**TR030002: Application by York Potash Limited for an Order Granting
Development Consent for the York Potash Harbour Facilities**

Examining Authority’s First Round of Questions

27 July 2015

| DRAWING No. | PB1586-SK121 | REVISION | D |

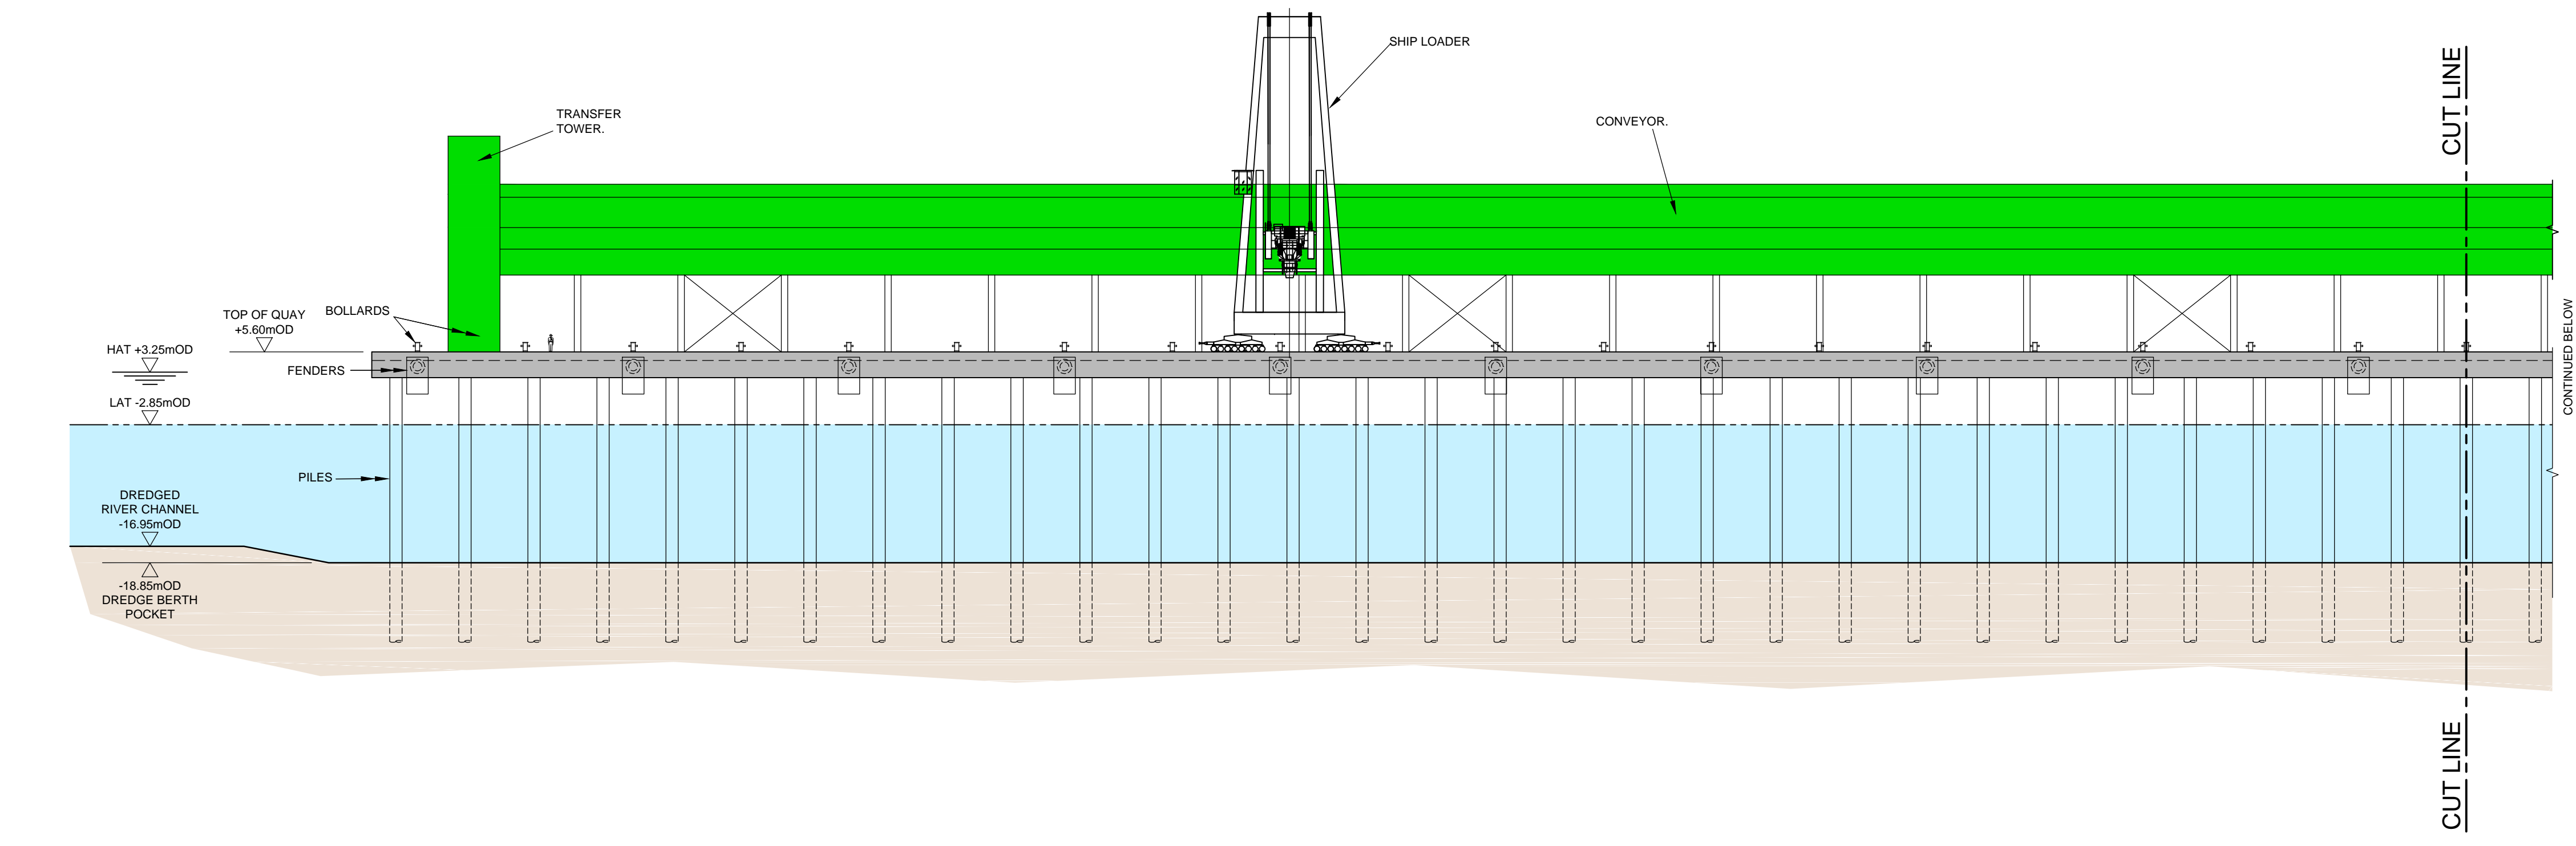
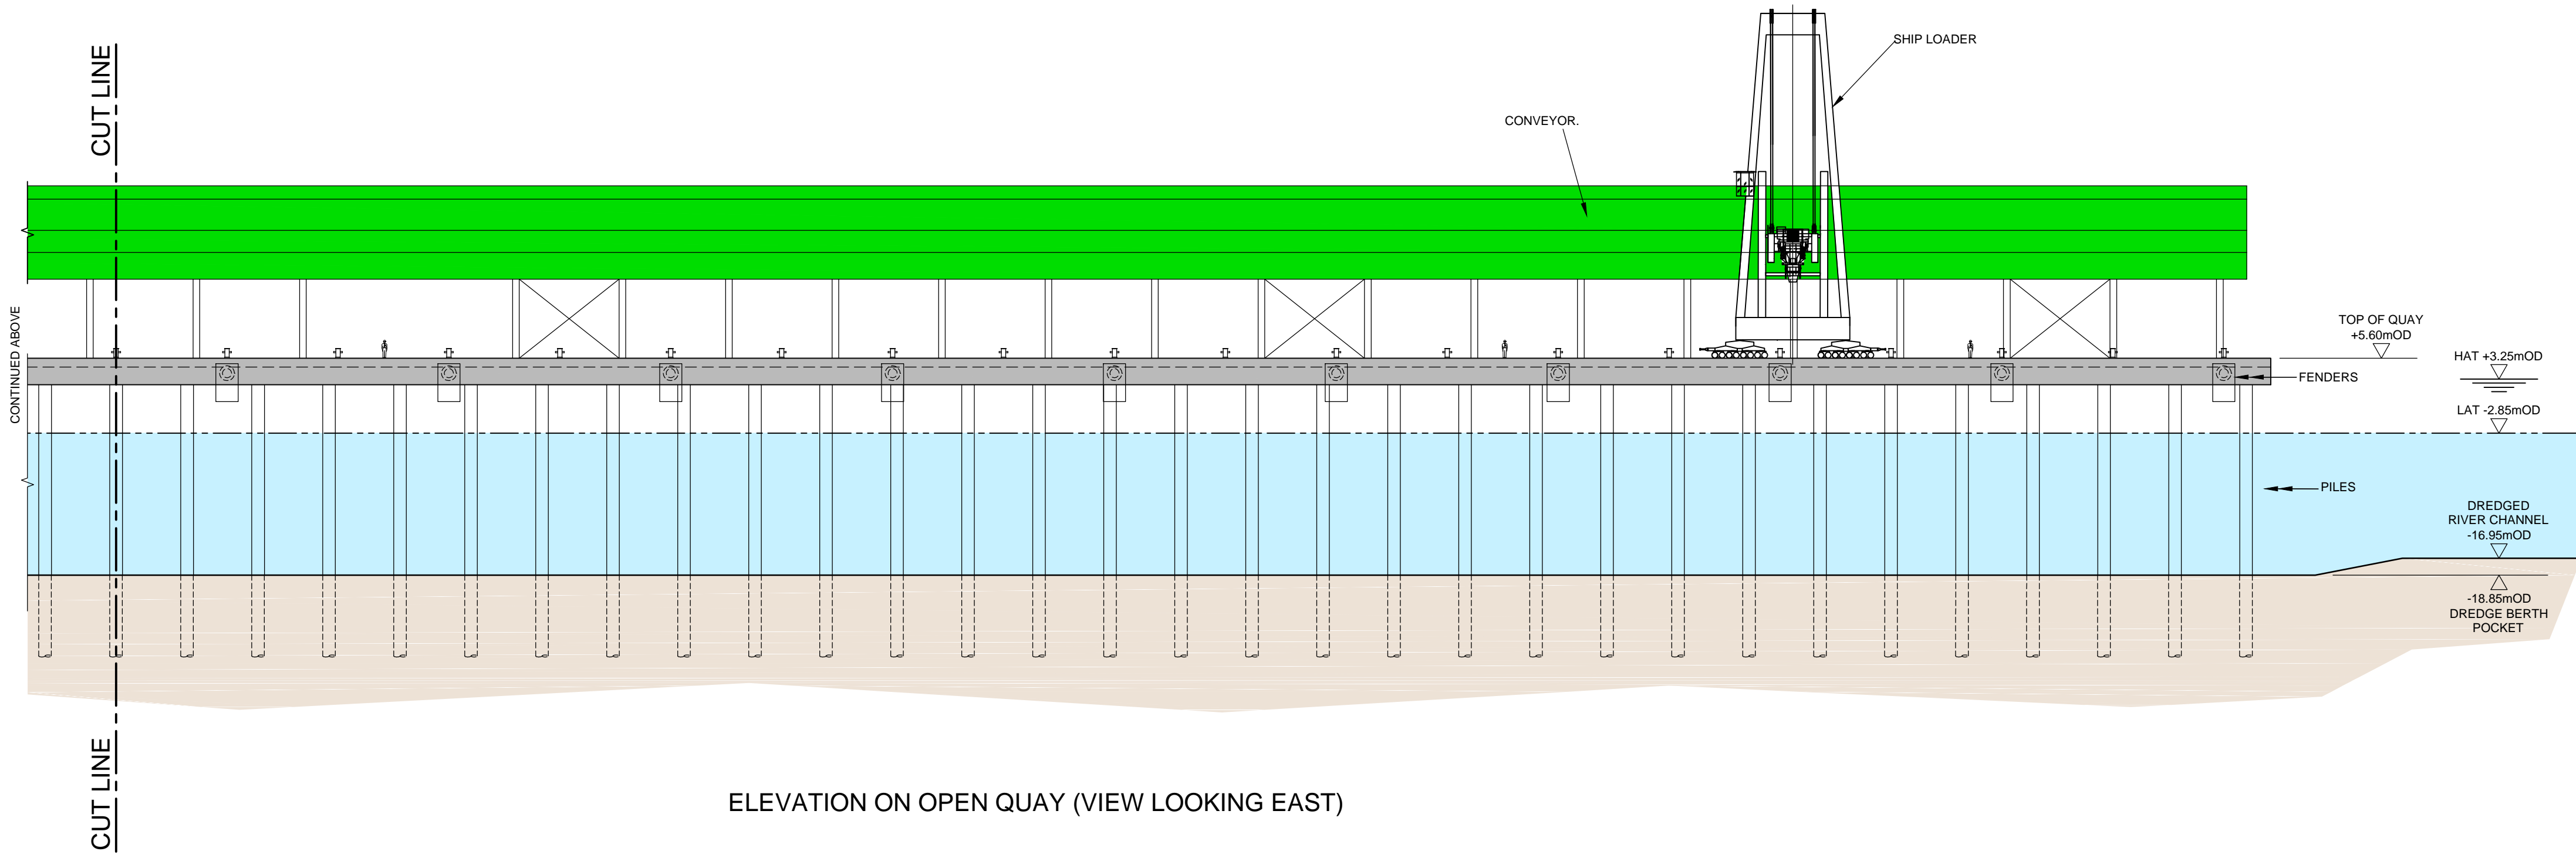
Given the options for conveyor routings and quay construction,

- a) how can you justify the proposed powers of compulsory acquisition over land that will not be required as implied by the phraseology 'as may be required for the purposes of the authorised development' in articles 29 and 30 of the draft DCO?
- b) do you intend to confirm the actual extent of your requirements during the Examination?
